Your Ref: OWPC14801
Our Ref: BN/20/17/HH 16-05-2017
Please ask for:
Richard Temple

Demolish existing unit & replace with a replica roof extension
Clytha Cottage Yapton Road Barnham

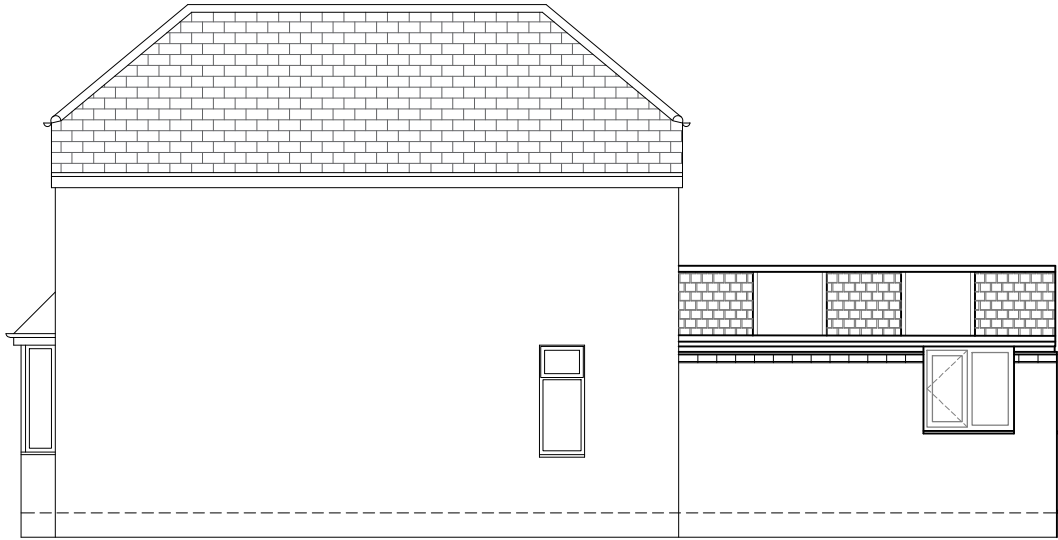
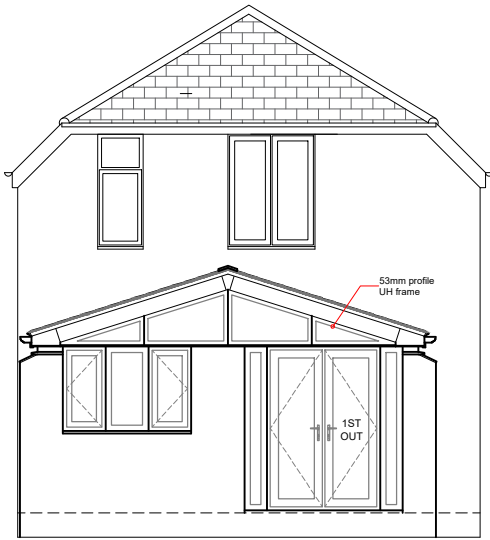
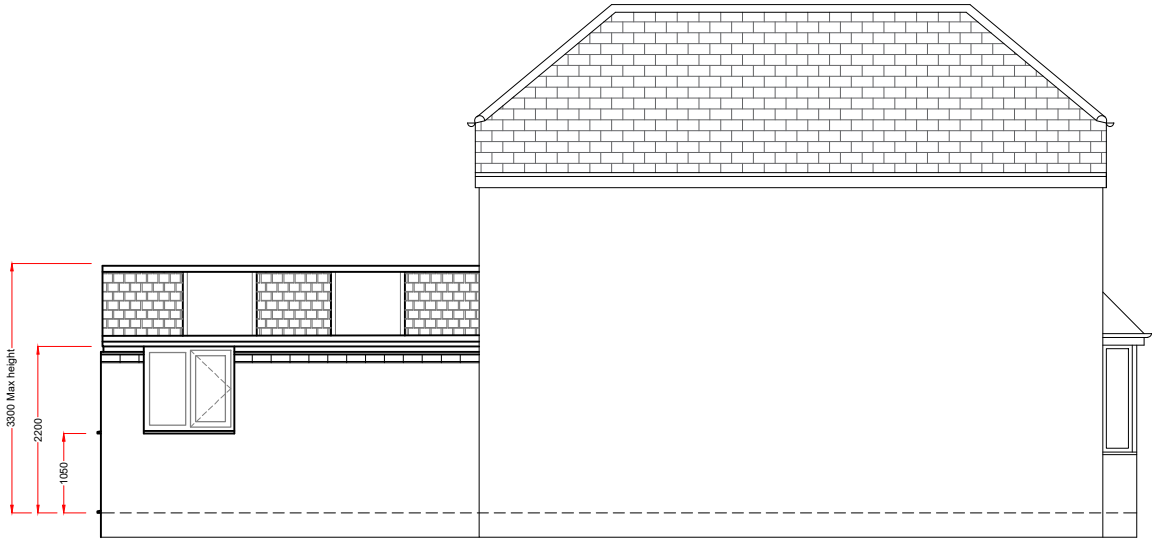
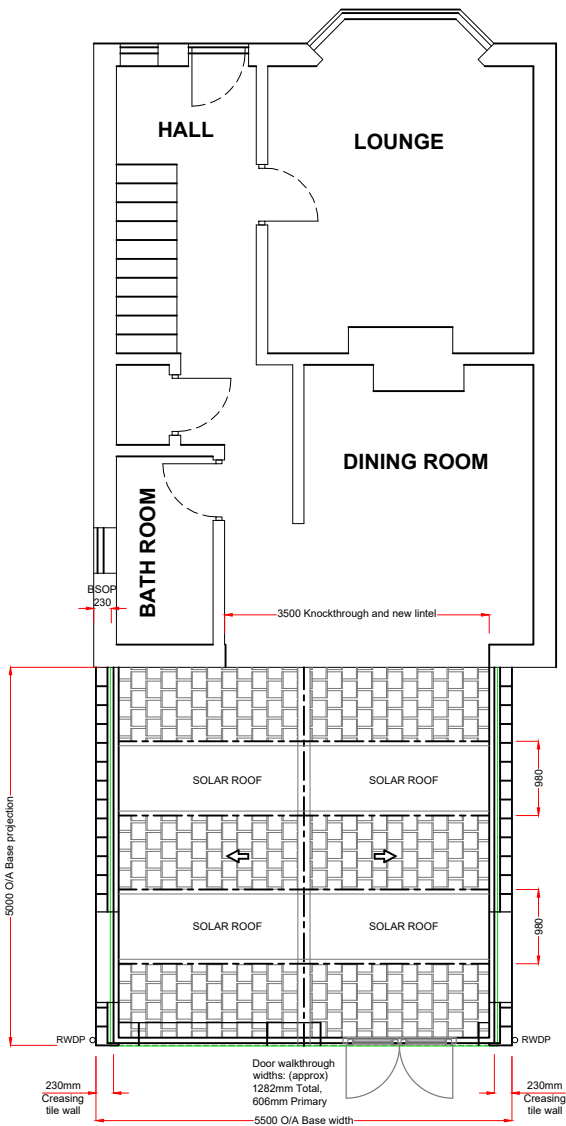
Regarding the demolition of existing extension, I believe the existing tiles to be of Asbestos nature which is an obvious danger to everyone. New roof structure to be of tin and glass which is not in keeping with the rest of the house
